Rezoning Transportation Analysis

Petition Number: 2022-209

General Location Identifier: 12520104

Date	Description
4-27-23	First Review (PDM)

RZ 1.0

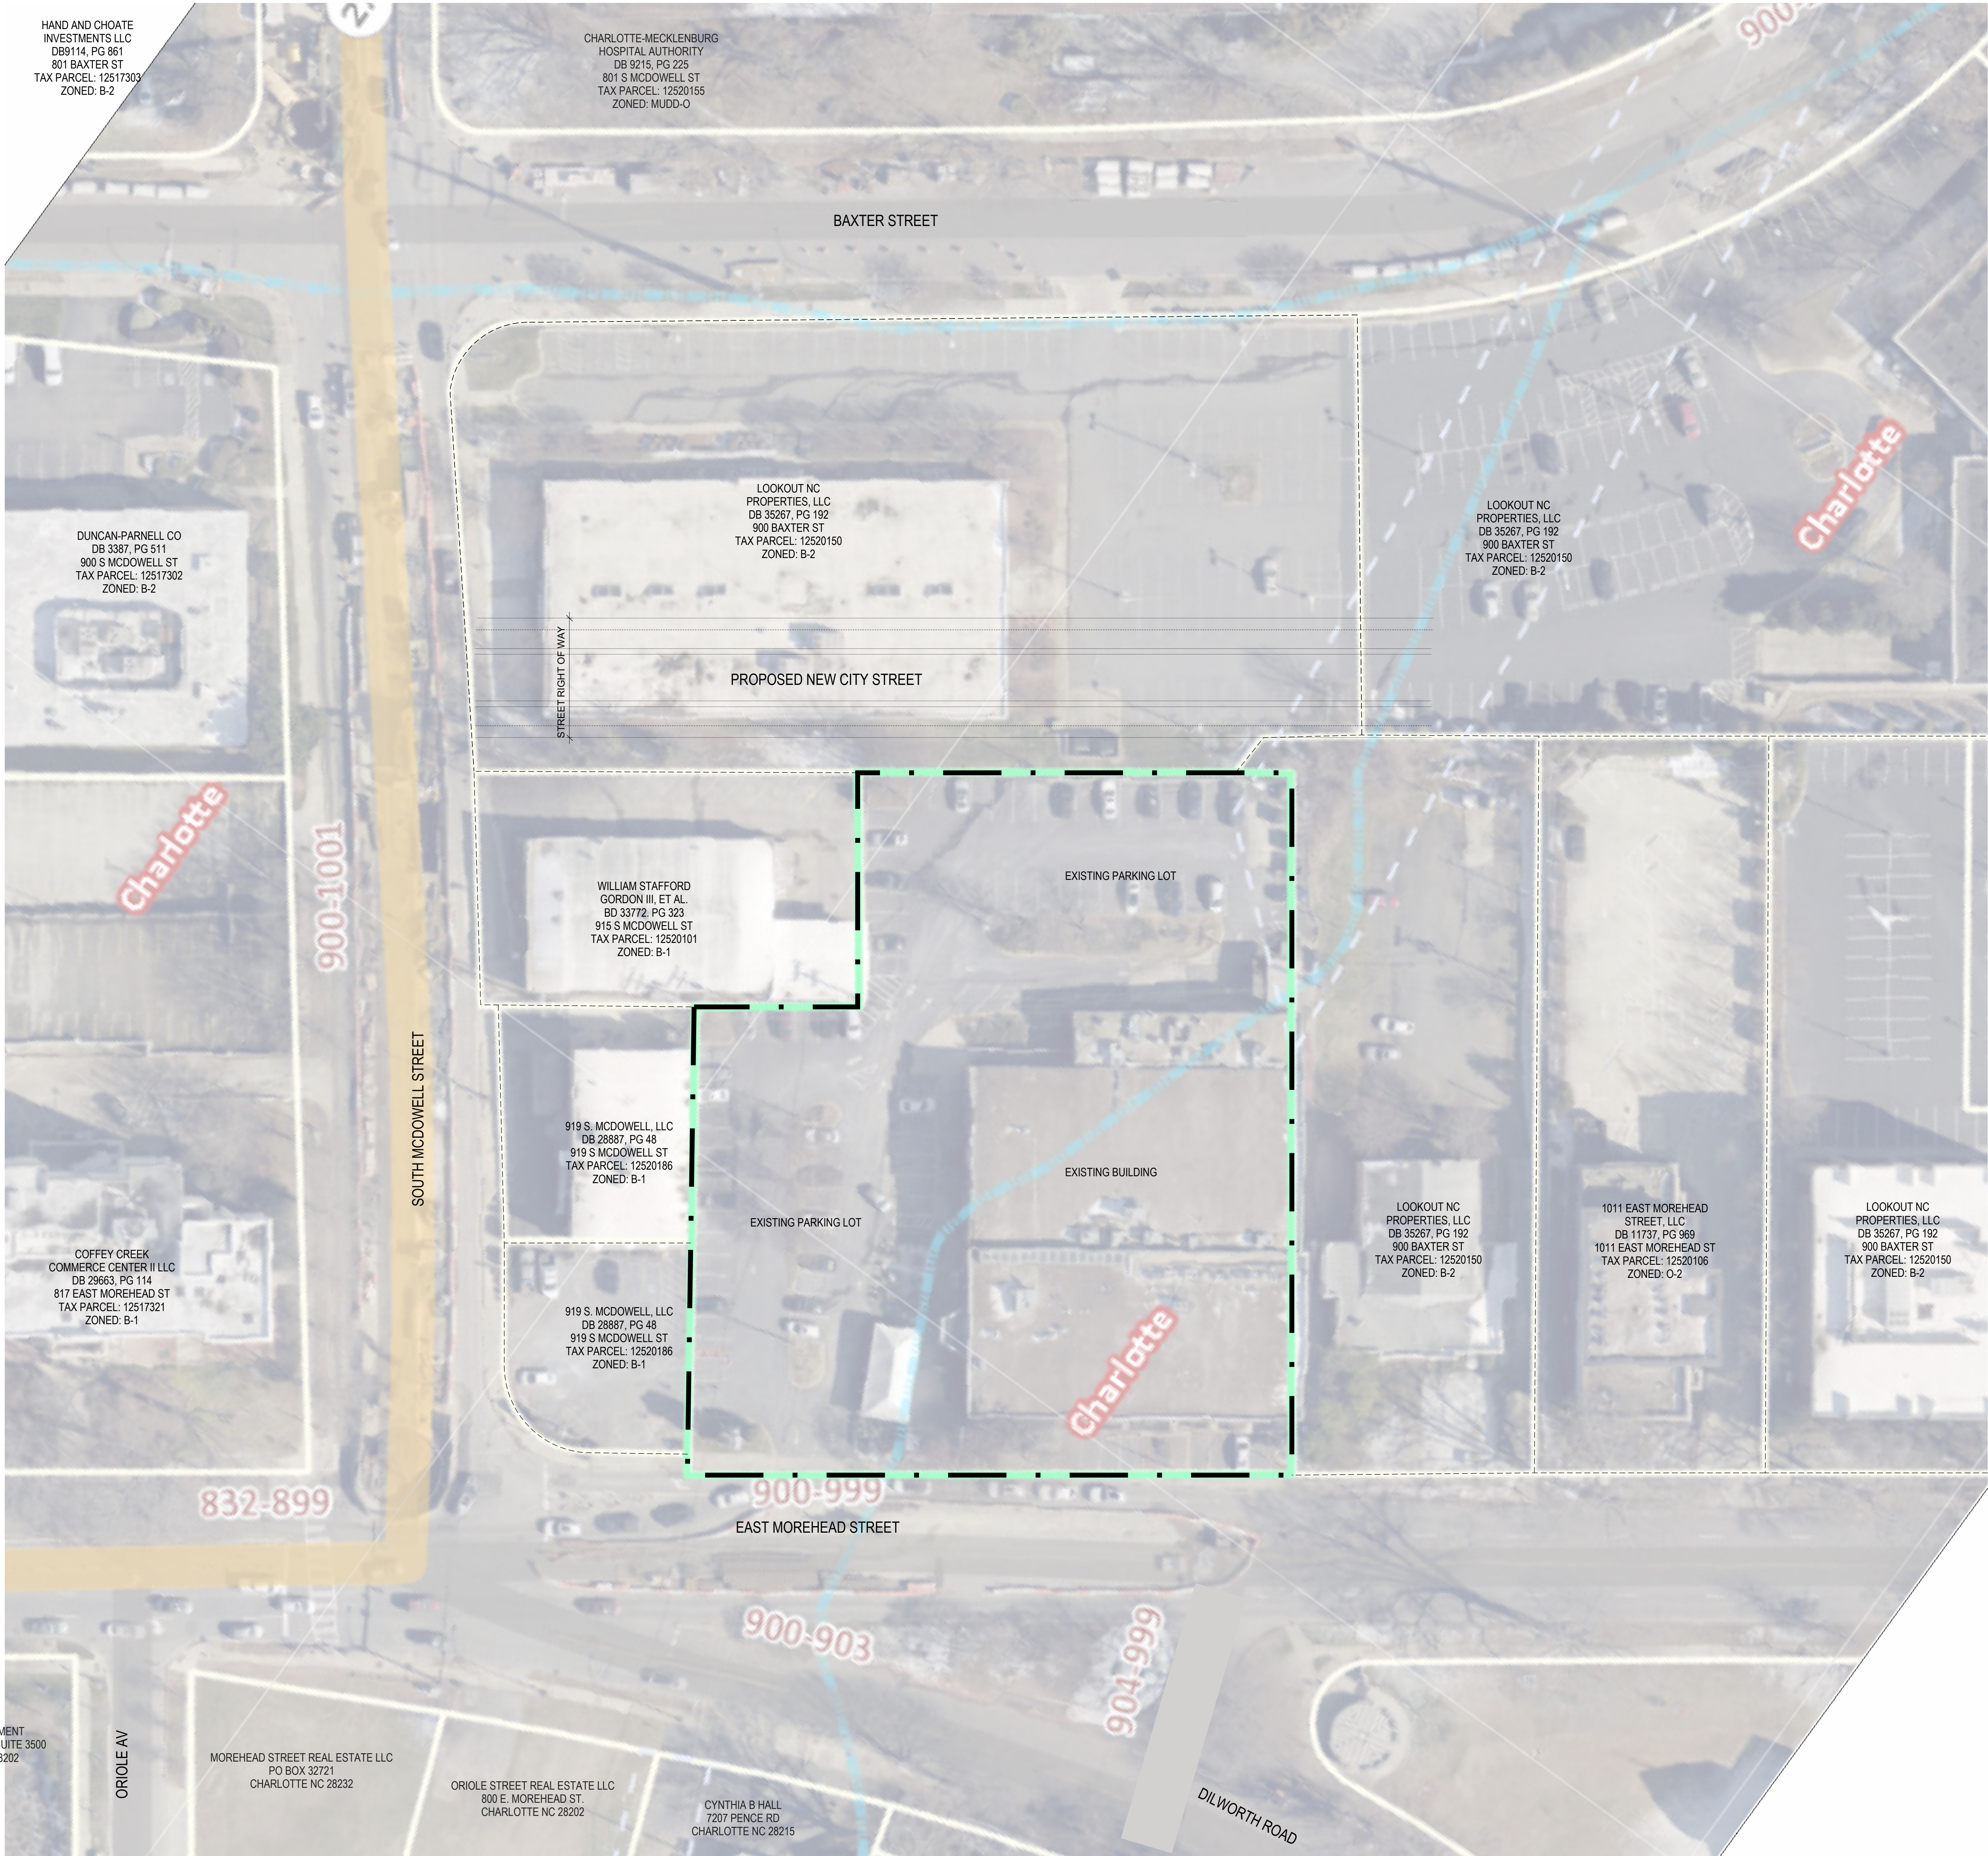
Morehead Street: Location of curb and gutter to be moved to 38 feet from roadway centerline to accommodate the Charlotte Streets Map with a roadway typical section of a four plus avenue with buffered bike lanes.

Label and dimension the curb and gutter from the centerline for each road on the site plan.

3. Revise site plan and conditional note(s) to commit to dedicate a minimum of 40-feet of right-of-way from the road centerline. The site plan shall label and dimension the right-of-way from the road

centerline. In addition, provide sidewalk utility easement if the proposed sidewalk facility will be located outside of the ROW.

4. Revise site plan and conditional note(s) to extend the existing concrete median along Morehead to the Dilworth Road connector.

5. Revise site plan and conditional note(s) to commit to construct an 8-foot planting strip, and 8-foot sidewalk on Morehead Street per Chapter 19. The site plan shall label and dimension both items from the back of the future curb and gutter location.

6. Revise site plan and conditional note(s) to clarify who is constructing the offside proposed street, and that a cross access easement is required to access the street across private property.

7. Revise site plan and conditional note(s) to commit to construct bicycle facilities by locating the curb and gutter 38 feet from the center line to meet the Council-adopted Charlotte BIKES Policy.
